WEST SUSSEX COUNTY COUNCIL CONSULTATION

TO:	Arun District Council FAO: Hebe Smith
FROM:	WSCC – Highways Authority
DATE:	25 August 2026
LOCATION:	21 Longford Road Bognor Regis PO21 1AB
SUBJECT:	BR/134/26/PL Change of use from dwelling house (use class C3) to 8-bed, 8-person house in multiple occupation (Sui Generis) to include a rear extension and loft conversion. This application is in CIL Zone 4 (Zero Rated) as other development.
DATE OF SITE VISIT:	n/a
RECOMMENDATION:	Advice

Drawing No: 260107 - 3.01 Rev: B

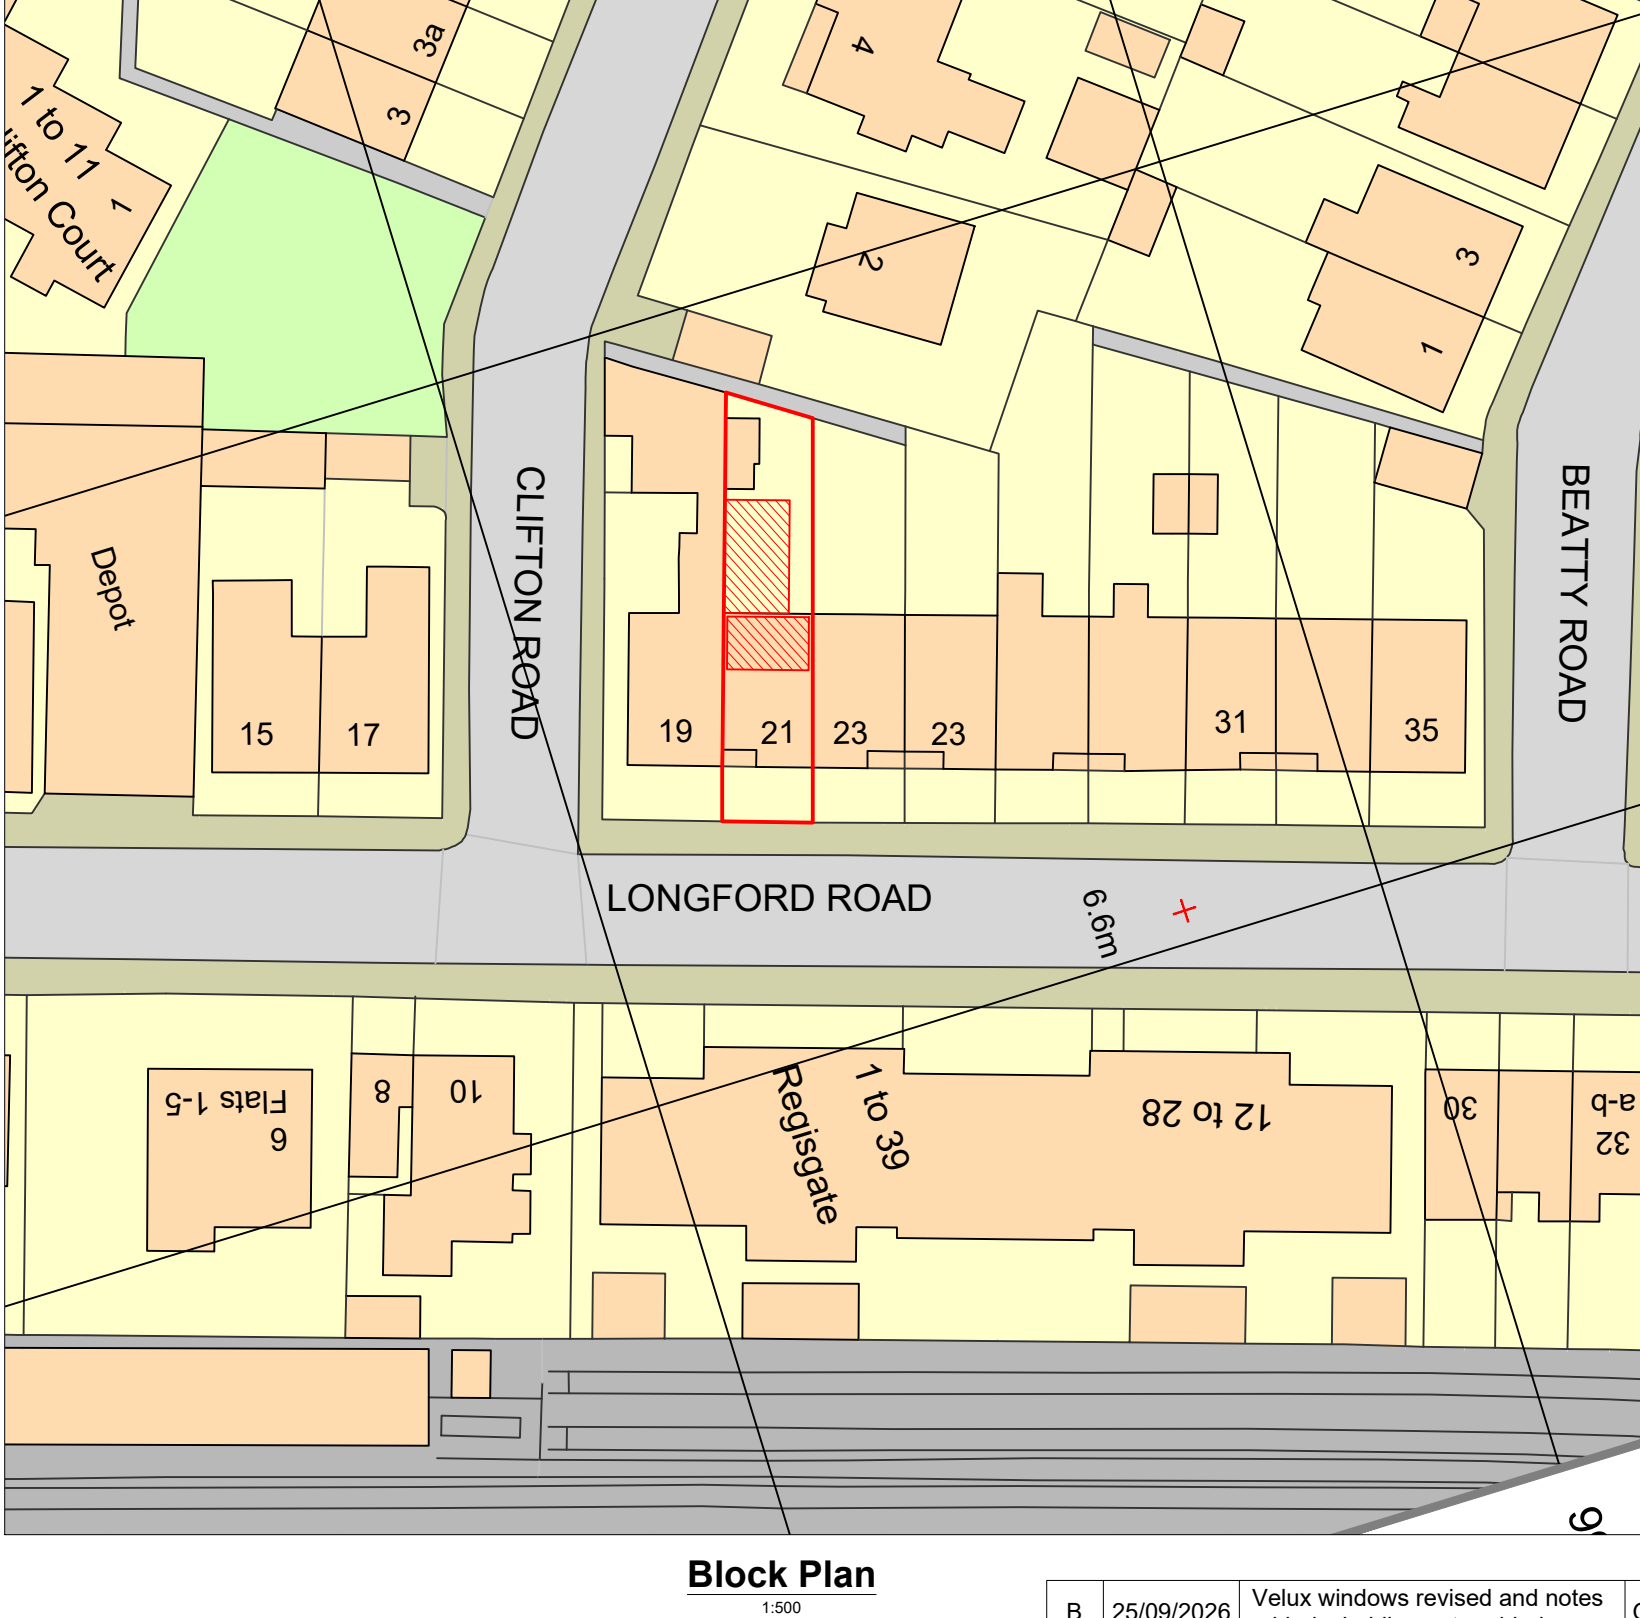
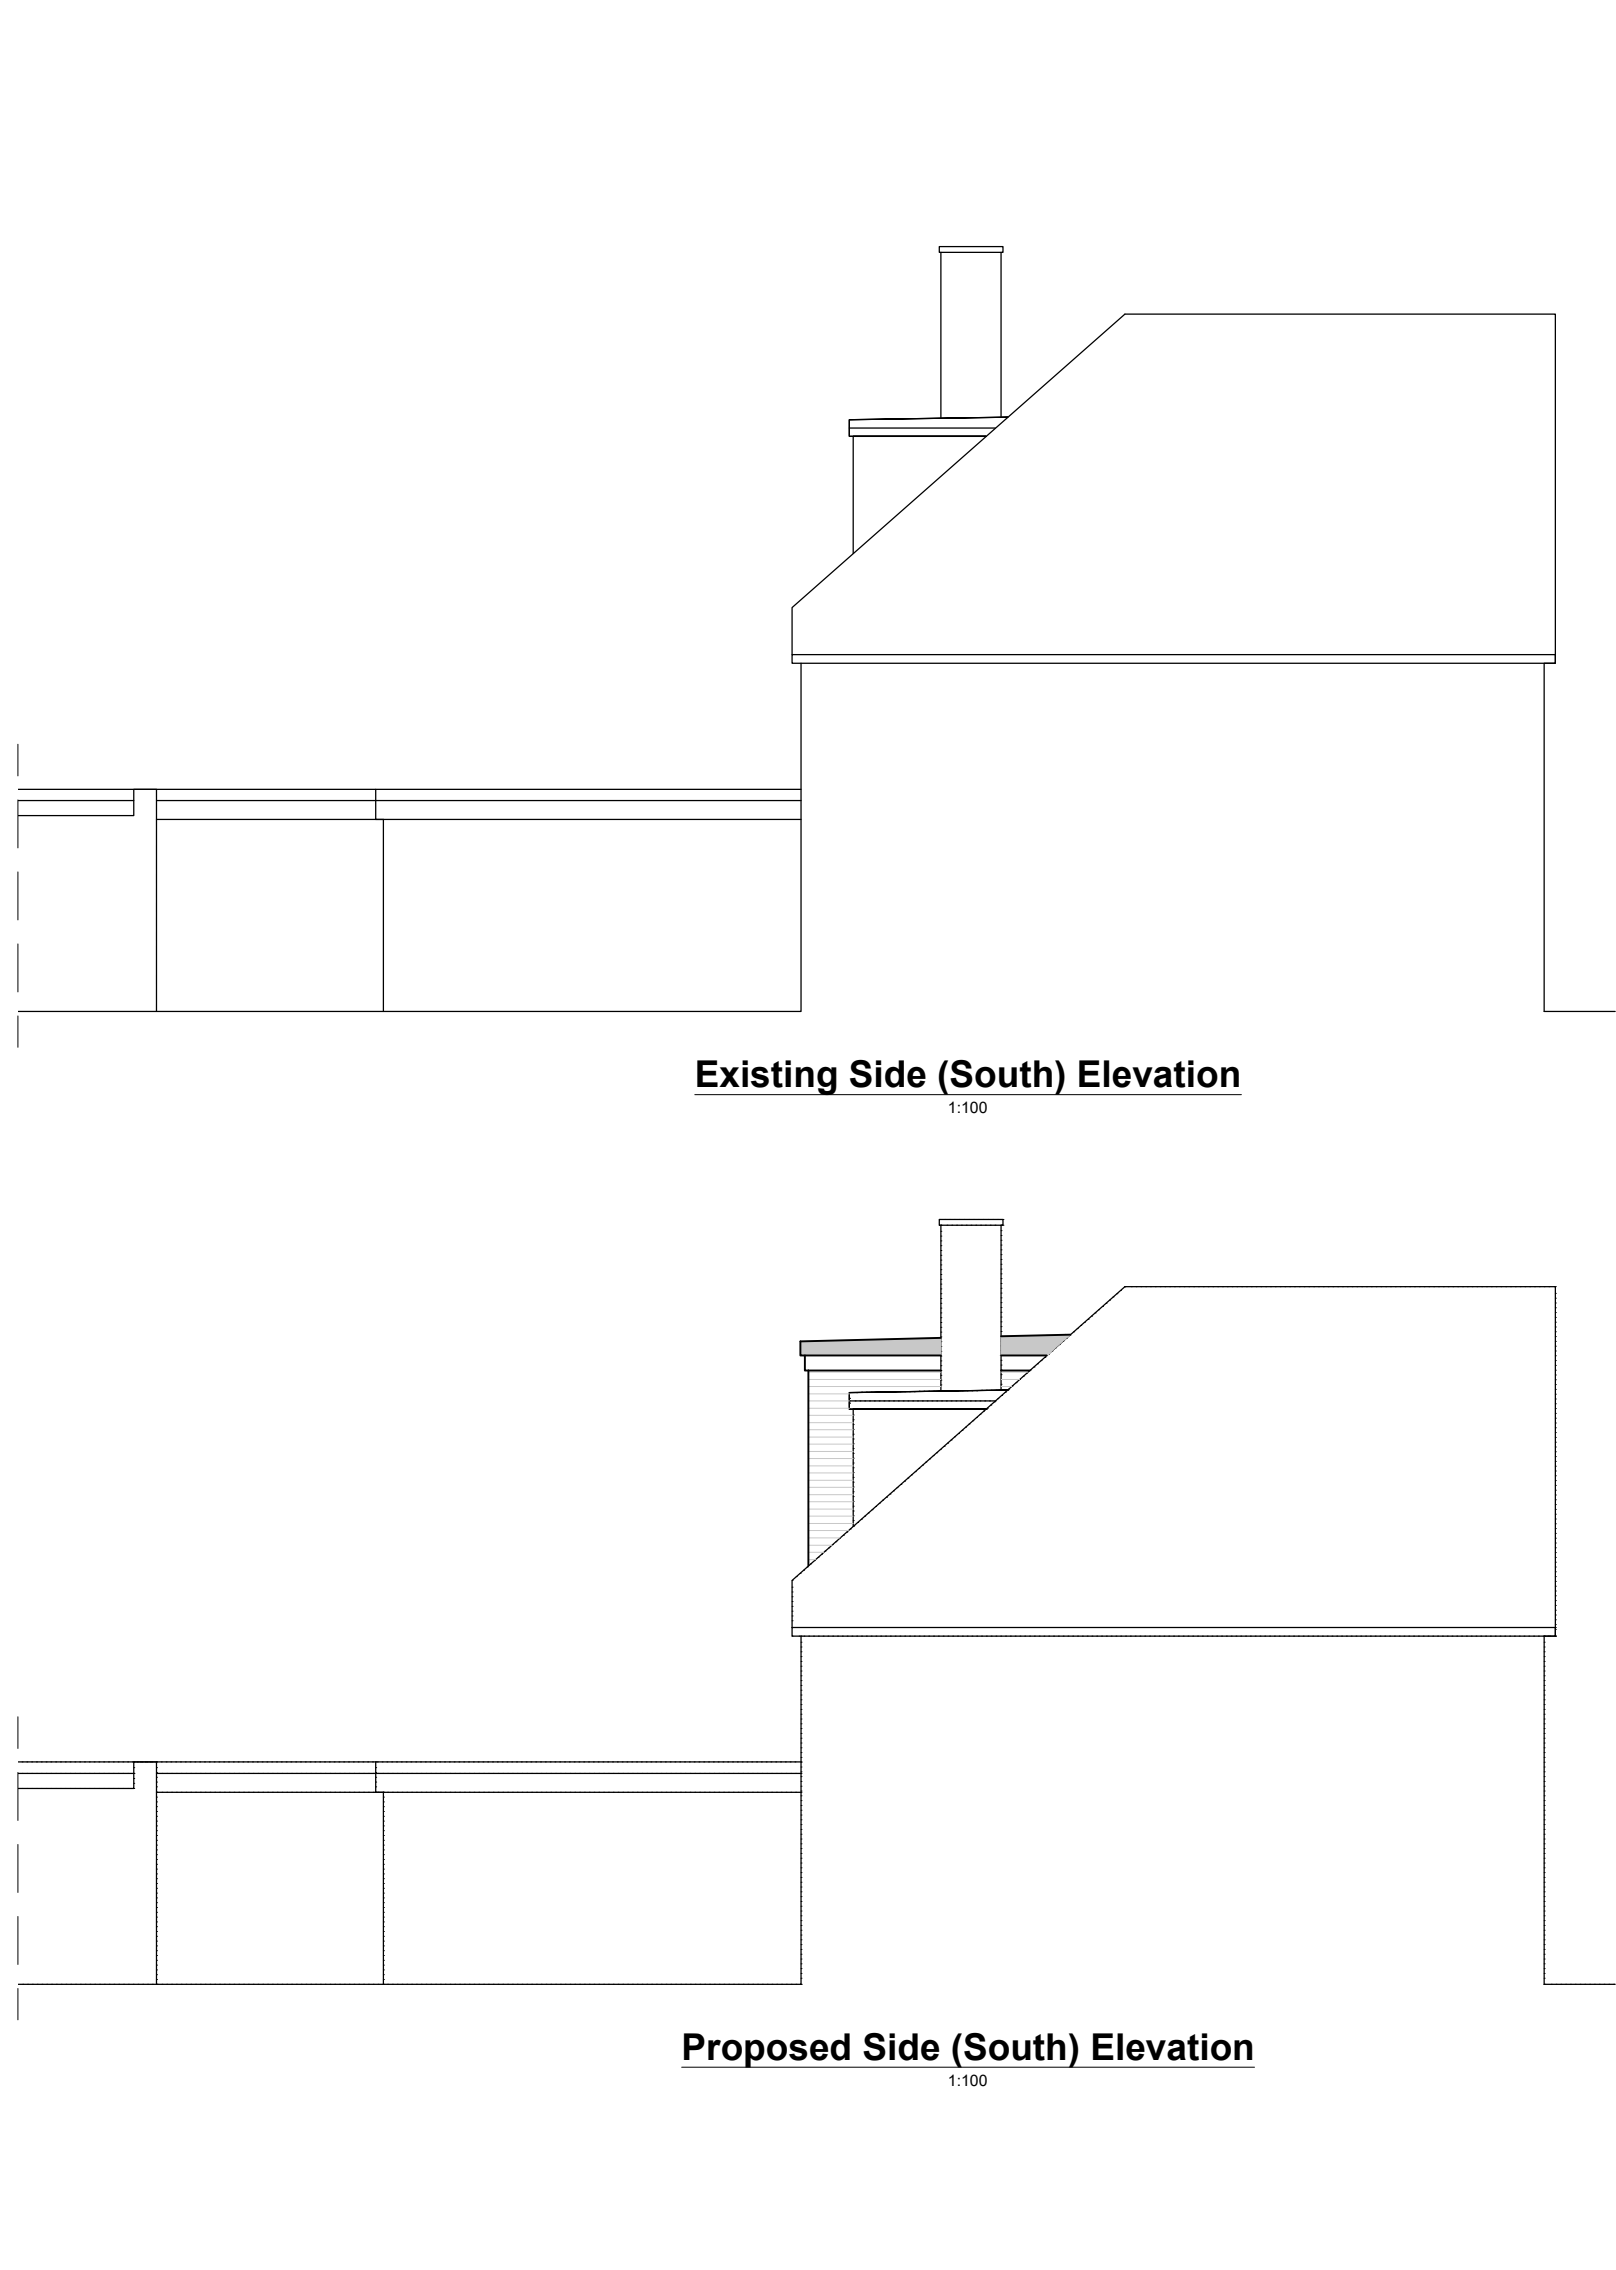
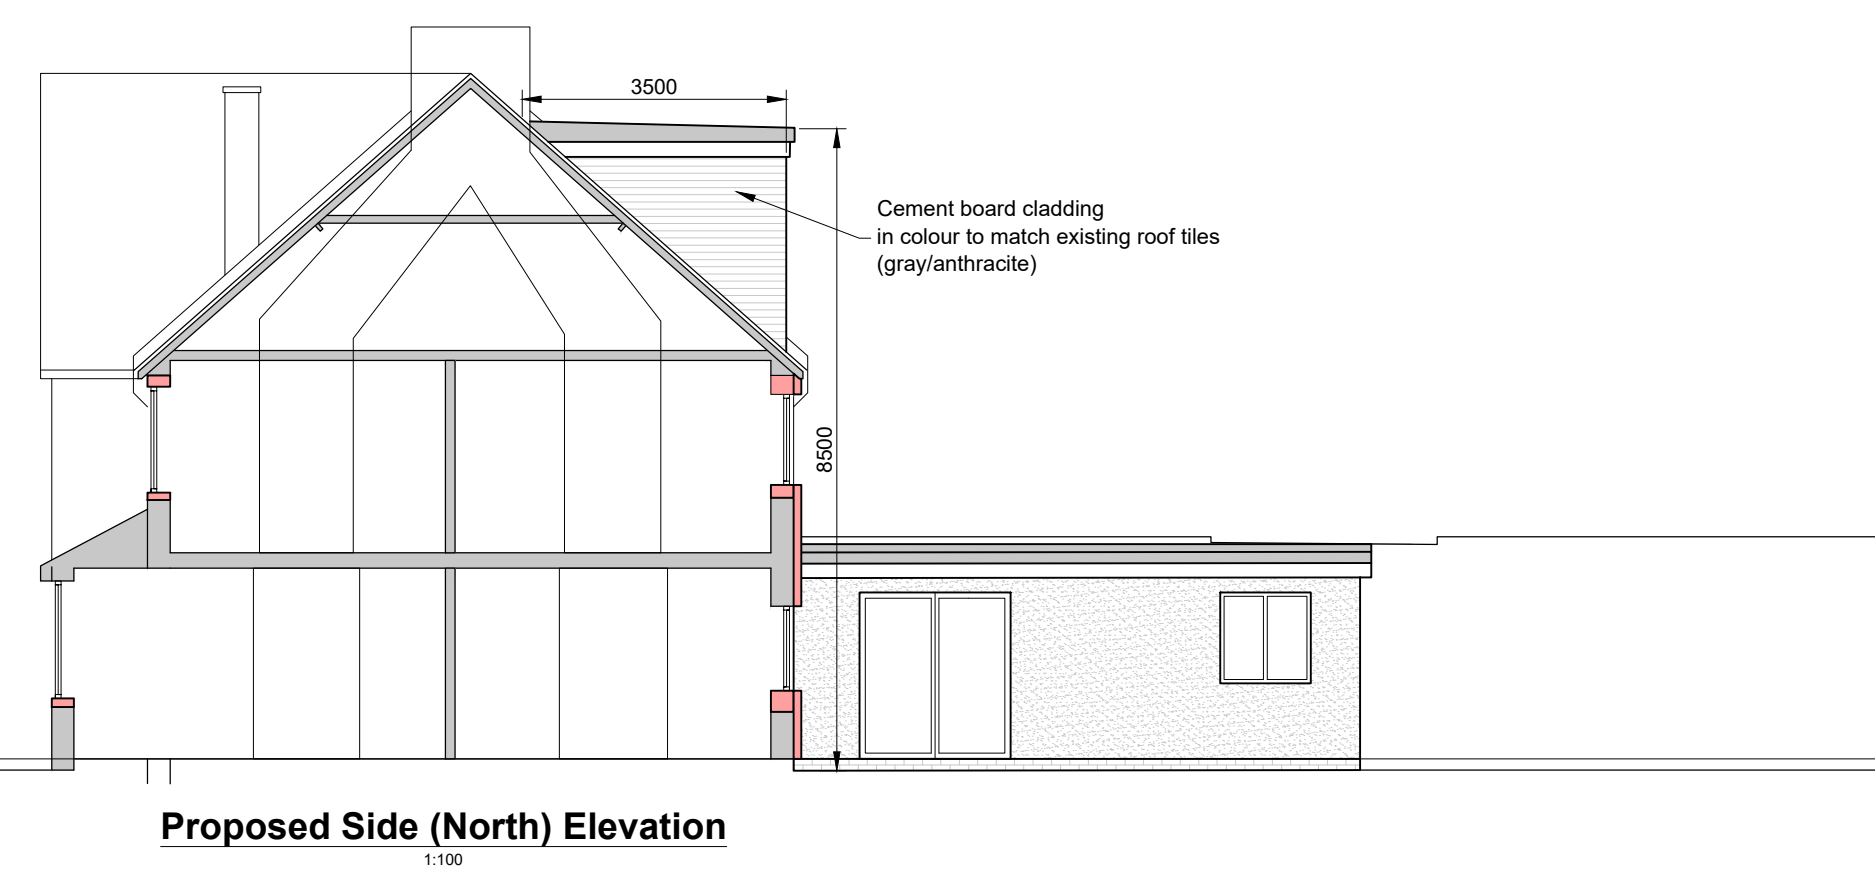
Provision for the storage of bicycles has been demonstrated to the rear of the site. The cycle parking proposed appears to be in the form of vertical hanging racks. The LHA would advise that Sheffield stands are preferred due to their ease of access. Sheffield stands should be spaced in accordance with the guidance in Manual for Streets (Figure 8.6 page 102). Whilst stands other than the Sheffield can be acceptable, vertical hanging racks and butterfly stands only allow the front wheel to be secured. These types of stands can be difficult for some users to lift their bike into position and don't allow users to easily secure the frame and both wheels; so are less secure.

The details of the cycle parking provision can be secured via a suitably worded condition- advised below.

No part of the development shall be first occupied until covered and secure cycle parking spaces have been provided in accordance with plans and details to be submitted to and approved by the Local Planning Authority.
